Re: **Peak Technology Campus – Initial Review Comments – SWENT Comments added 1/29  
AR CP 18-00709-A3MJ20 & AR DP 20-00865**

The following list is to address each review comment made regarding the Concept Plan and Development Plan submittal review. The referral agency comments are in italics. Our response is in bold text.

16 **7**

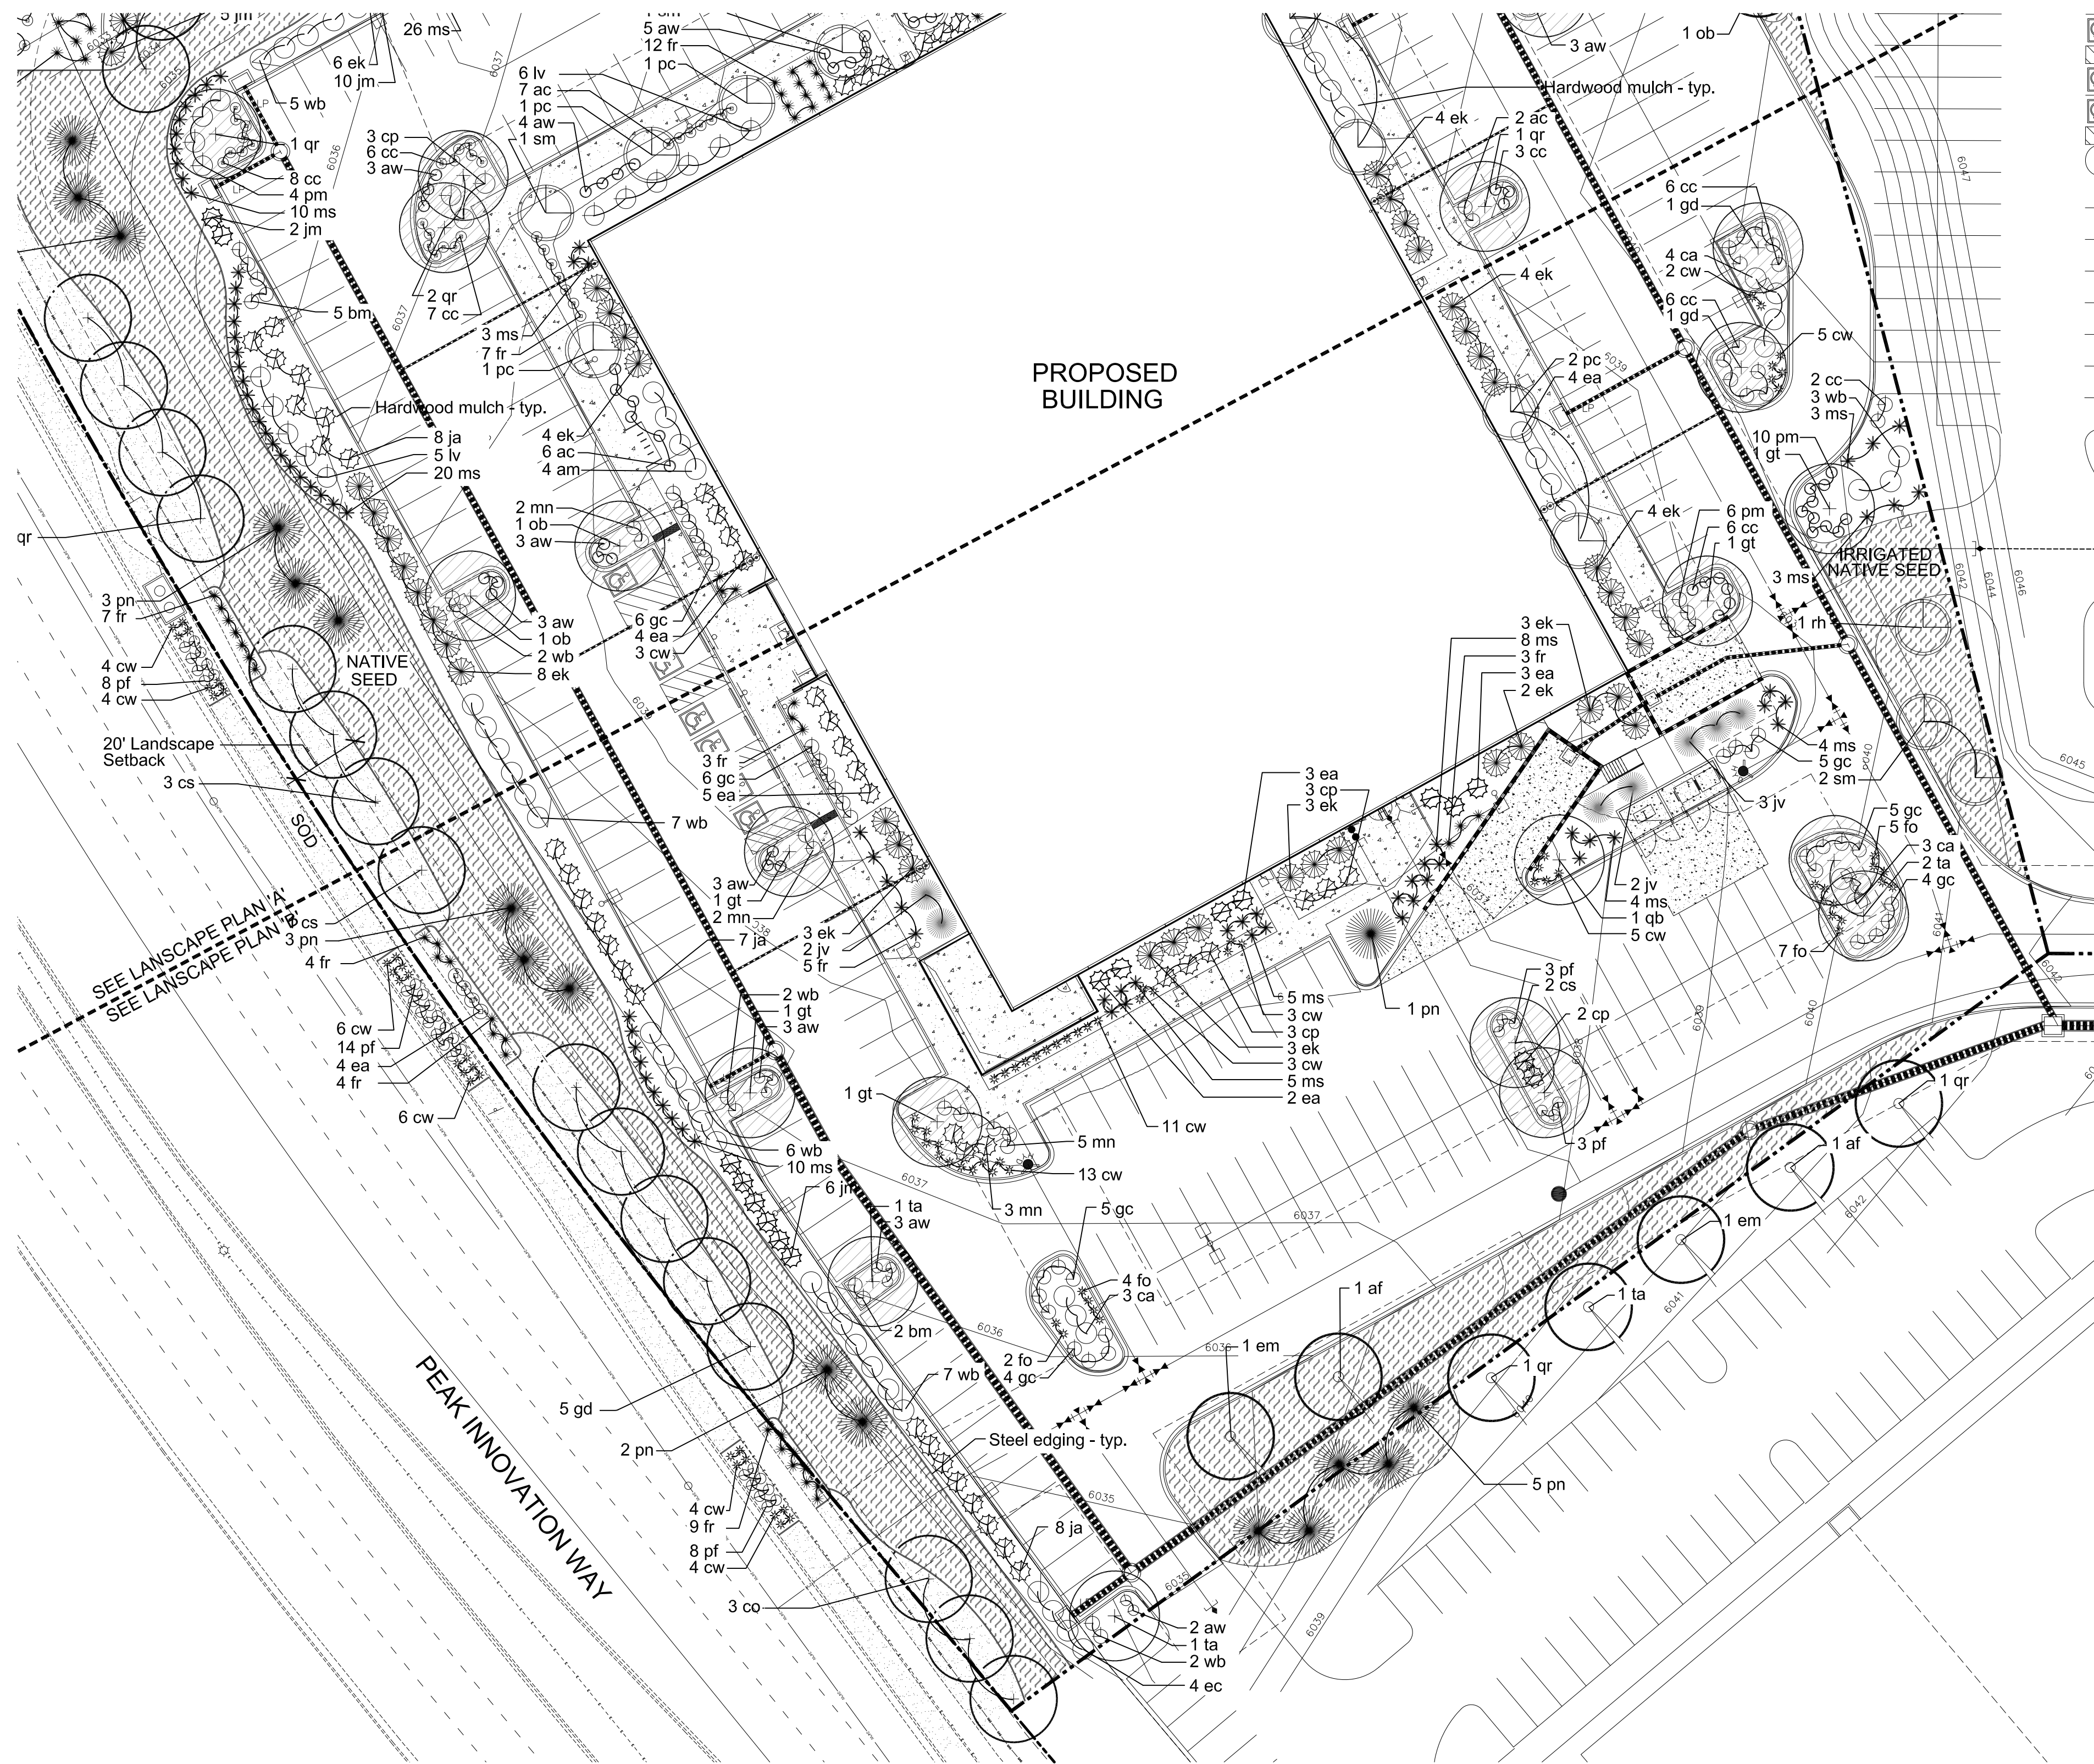
Sheet 7 of 16:

- Change Cresterra Parkway to Peak Innovation Parkway

**Response:** Revised as requested.
